Town & Country Planning Act 1990 (as amended)
Town and Country Planning (Development Management Procedure) (England) Order 2015
Application for approval of details reserved by condition imposed under planning permission
BR/282/13 relating to condition No. 3 (Cycle storage), 4 (Storage of waste and recycling)
28 Canada Grove Bognor Regis,,

Arun District Council have decided to **APPROVE details reserved by this condition**
The submitted details in respect of the storage of waste and recycling namely the proposed shed enclosures on the south-eastern end of the site as detailed on :-

SECURE BIN & CYCLE STORAGE PLAN Dr 2b

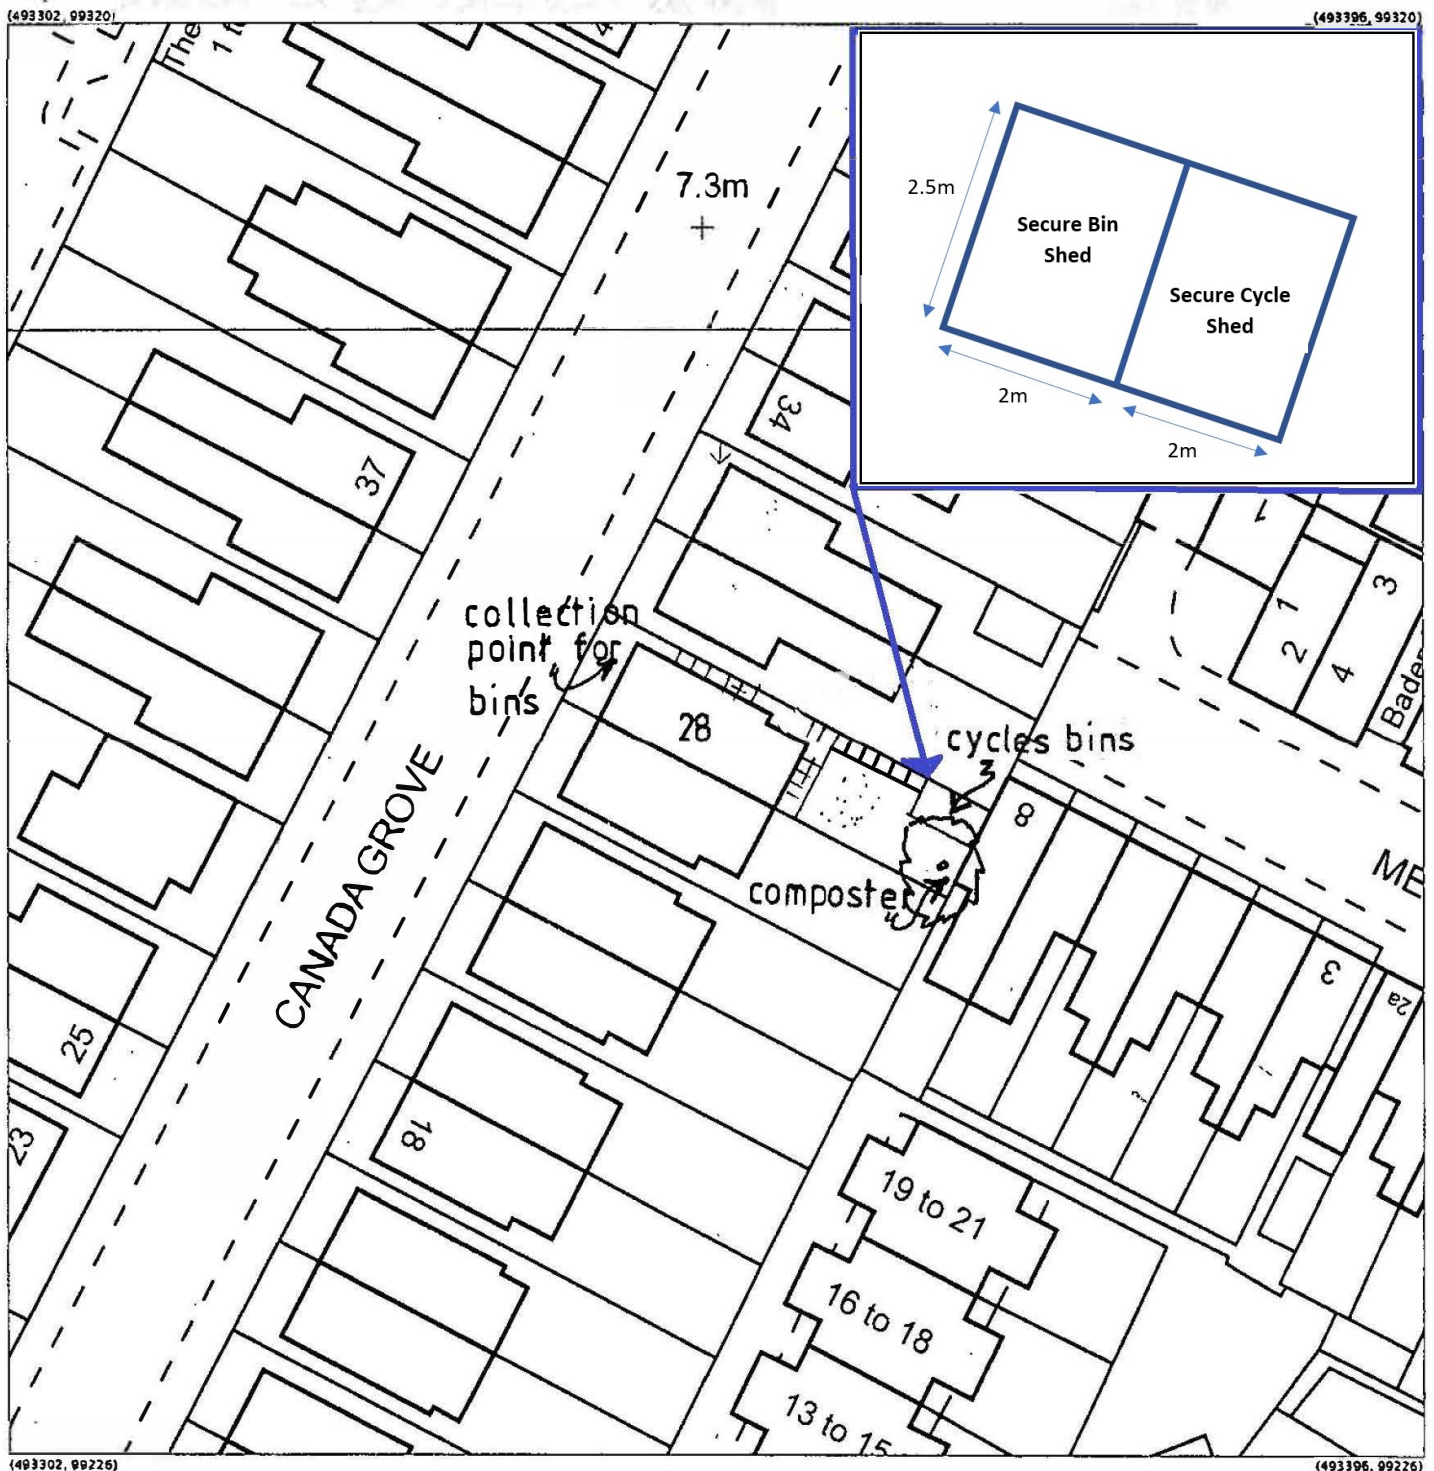
Secure Bin & Cycle Storage plan Dr2b version 1
Secure Bin & Cycle Storage Elevation Plan version 1

are considered to provide an acceptable scheme and satisfies the requirements of the condition.
